DECISION DELEGATED TO HEAD OF PLANNING

Application No: H01-0140-24 **Applicant:** Coda Builders Ltd

Proposal: Erection of 3 detached dwellings - approved under H01-0234-23.
Modification of Condition 2 to allow amendments to previously approved plans and Condition 3 to allow amendments to external surfaces and removal of chimney to Plot 3

Location: Land North Of 68 Stonegate Cowbit Spalding

DRAWING No.
074 P05

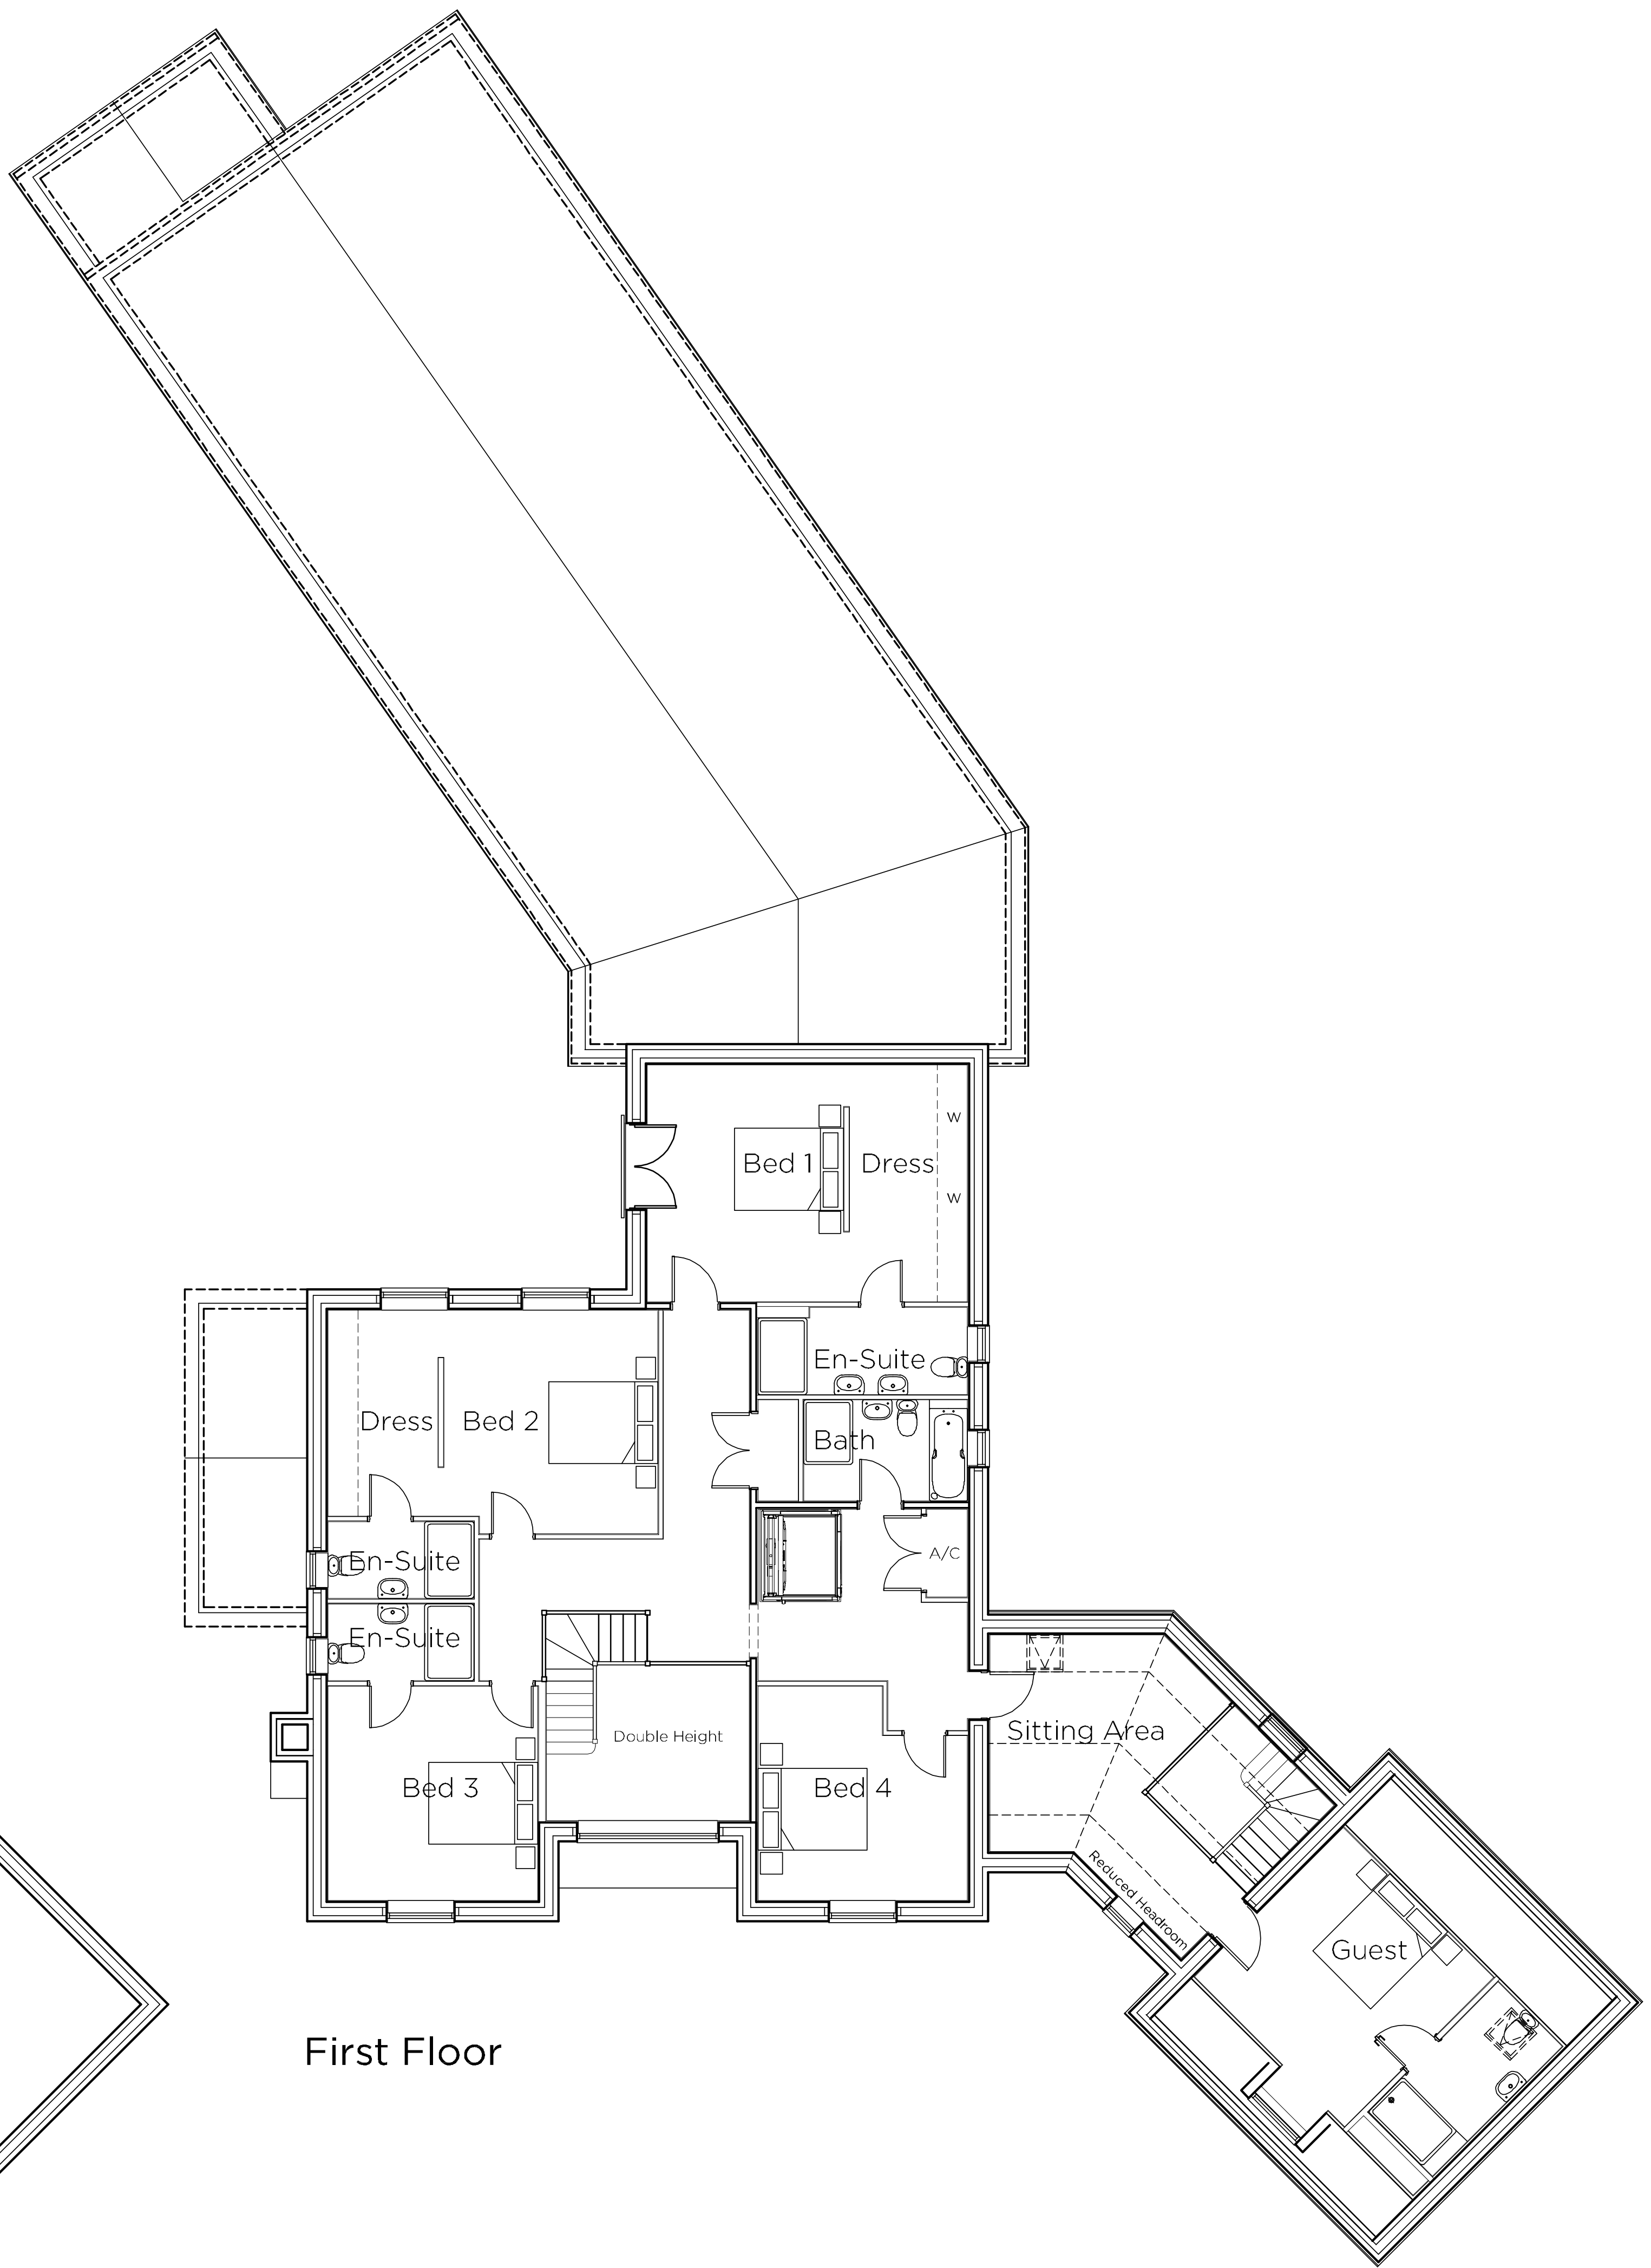
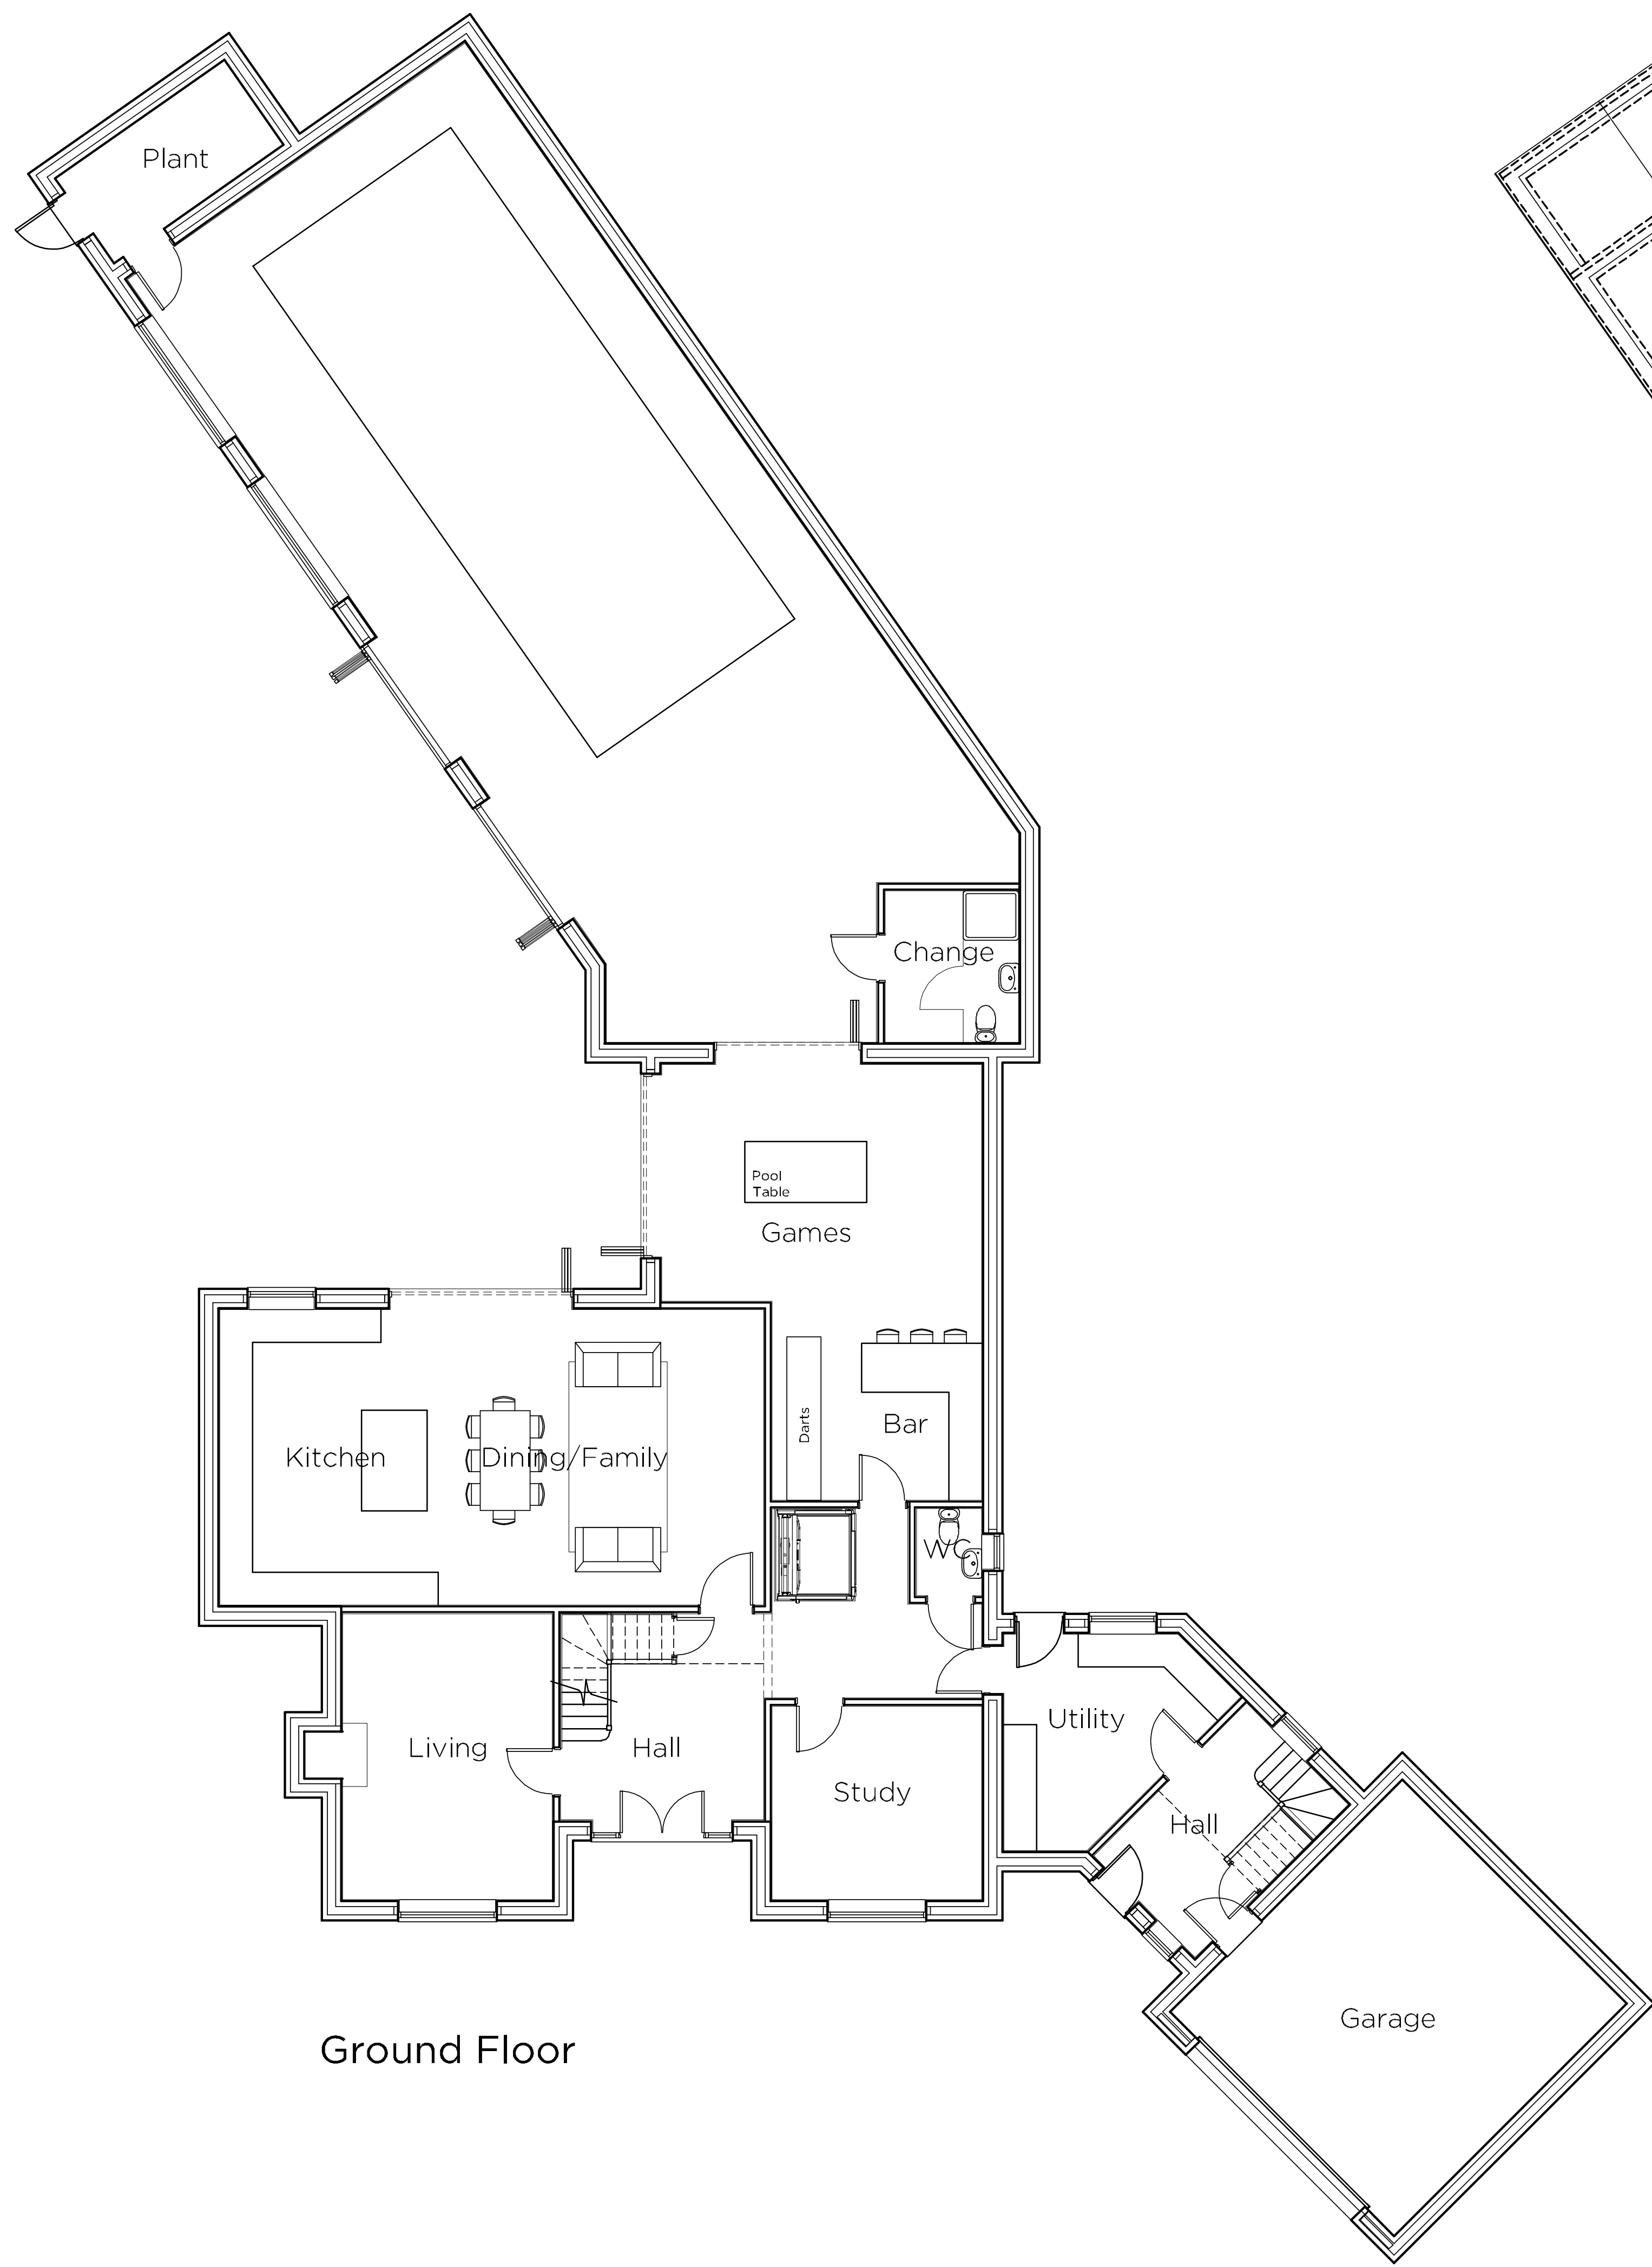
The proposal also seeks to remove the proposed chimney on the east elevation to Plot 3. The removal of the proposed chimney is considered to be acceptable and would not have an adverse impact to the character and appearance to the area.
